# Weir Phillips Heritage and Planning

<b>WOLLONGONG CITY COUNCIL   SSD-73910208   REQUEST FOR INFORMATION</b>
-------------------------------------------------------------------------

This Heritage response has been prepared to accompany a Request for Information from Department Planning, Housing and Infrastructure to the SSDA – 73910208 for the site at Nos 6-8 Popes Road, Woonona, New South Wales. The SoHI letter has specifically addressed the proposed works to the former Woonona Church on the site.

<b>2-8 POPES ROAD WOONONA</b>
	<b>DEVELOPMENT DESCRIPTION:</b> State Significant Development – Seniors Housing – IRT Woonona Redevelopment (SSD-73910208) - Redevelopment of existing Seniors Housing development including the construction of five (5) apartment buildings containing independent living units, adaptive reuse of existing church, alterations/additions to existing Residential Care Facility, wellness hub, landscaping and car parking
<b>1</b>	<b>RFI</b>
	The view corridor to the heritage building from the north of Princes Hwy is successful, however the applicant is encouraged to also improve view lines to the heritage building from the south of Princes Hwy by potentially cutti

**Figure 27 | Proposed ground floor plan showing alterations and additions to heritage building (source: Applicant's documentation).**

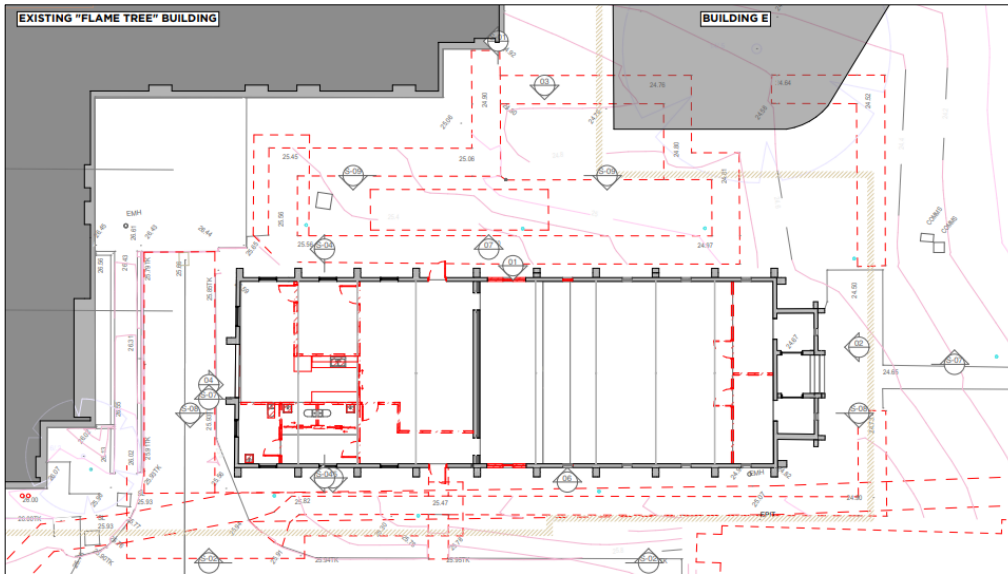
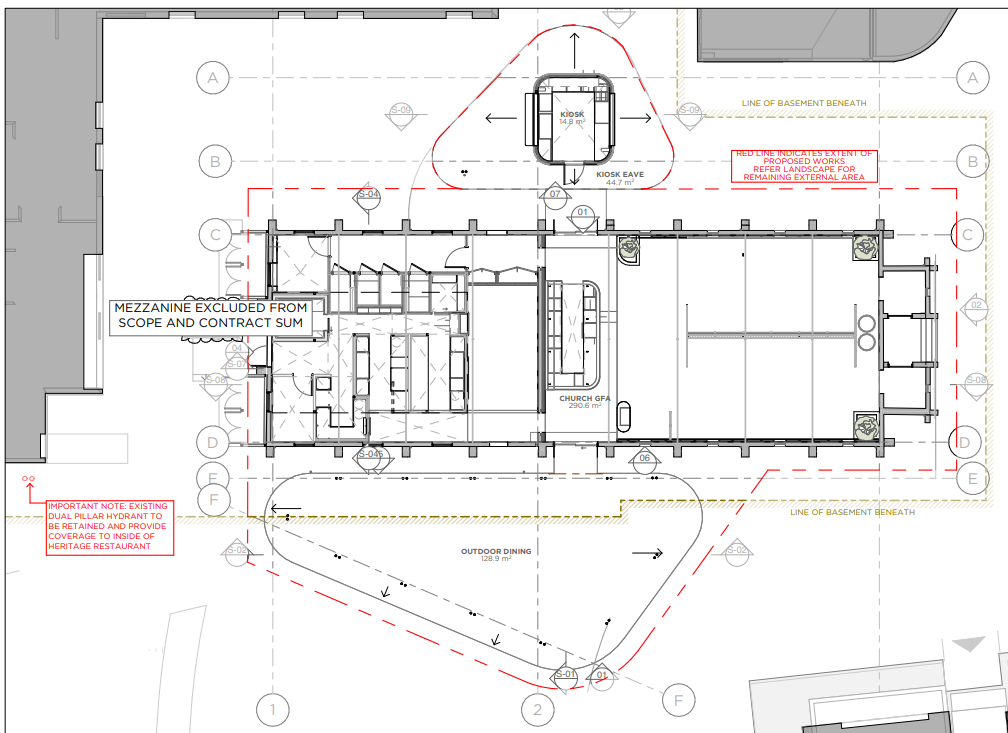
6	<p><b>RFI</b></p> <p>The EIS and HIS notes that internal reconfiguration and demolition works are proposed to the Church building to support a change of use to a restaurant and all fit out and services will be reversible.</p> <p>However there are no plans or detail of what work is proposed to the church building, how the additional pavilion and kiosk would function, what is proposed to be accommodate in the church building (kitchen, storage, dining etc). Floor plans and demolition plans are requested for the heritage item, and additional structures.</p>
6	<p><b>RFI RESPONSE</b></p> <p>The architectural drawings have now been revised to include plans and detail of the work proposed to the church building to adaptively re-use it as a restaurant and cafe, how the additional pavilion and kiosk will function, what is proposed to be accommodated in the church building (kitchen, storage, dining etc). Floor plans and demolition plans of the heritage buildings are now provided. Refer to the revised SSDA submission.</p> <p><b>Impact of the Proposed Works on 'Former Woonona Uniting Church'</b></p> <p>The Former church is comprised of two attached halls, the principal front hall and rear, secondary hall. Refer to Figure 33.</p>  <p>The floor plan shows the layout of the church building, divided into a Secondary Hall (left) and a Principal Hall (right). The Secondary Hall contains a Dining area, Meeting room, Office, Kitchen, Airlock, and Corridor. The Principal Hall contains a Hall area. The plan is annotated with red lines and text indicating renovation and demolition work, such as 'REMOVE EXISTING PARTITIONS, CEILING, LINEN, LIGHT FIXTURES, PLUMBING FIXTURES AND FITTINGS', 'REMOVE EXISTING CARPET FLOOR', 'REMOVE EXISTING FLOATING TIMBER FLOOR', and 'REMOVE EXISTING WINDOW FOR REUSE MAKE GOOD EXISTING BRICKWORK'. A dashed blue line outlines the perimeter of the building, and a dashed red line outlines the perimeter of the proposed works.</p>

- The principal significance of the hall interior is its internal volume created by the raked timber ceiling and arched windows which are retained.
- The proposed works to principal hall are minor in scale including the removal of the contemporary partition walls and rooms to the front of hall, near the entry and will help reinstate the original open plan of the hall.

- The partitions walls will be carefully removed to ensure there is no damage to any significant fabric.
- The two arch windows proposed to be removed will be carefully removed, protected and securely stored on site. It is also possible that they could be displayed within the church. The new openings created by the removal of the windows will enable compliant access to the proposed pavilions and will be carefully undertaken removing as few bricks as possible and openings made good with new joinery.

- The openings have been specifically designed to coordinate and align with the transom height and overall height of the arch windows to ensure they sit comfortably within the Church interior.

- Self-supporting stud walls will be constructed adjacent to the significant heritage walls to enable the installation of new joinery, hydraulic and electrical services to prevent any physical impact on the heritage walls.

- The secondary hall has been previously modified with a lowered ceiling and internal rooms to half of the hall.
- The proposed ceiling will extend the existing lowered ceiling to all of the secondary hall with the more significant raked ceiling retained above.
- The removal of the internal layout and joinery is either contemporary and less significant. It will be carefully removed to ensure no damage to the heritage fabric.
- Self-supporting stud walls will be constructed adjacent to the significant heritage walls to enable the installation of new joinery, hydraulic and electrical services to prevent any physical impact on the heritage walls.
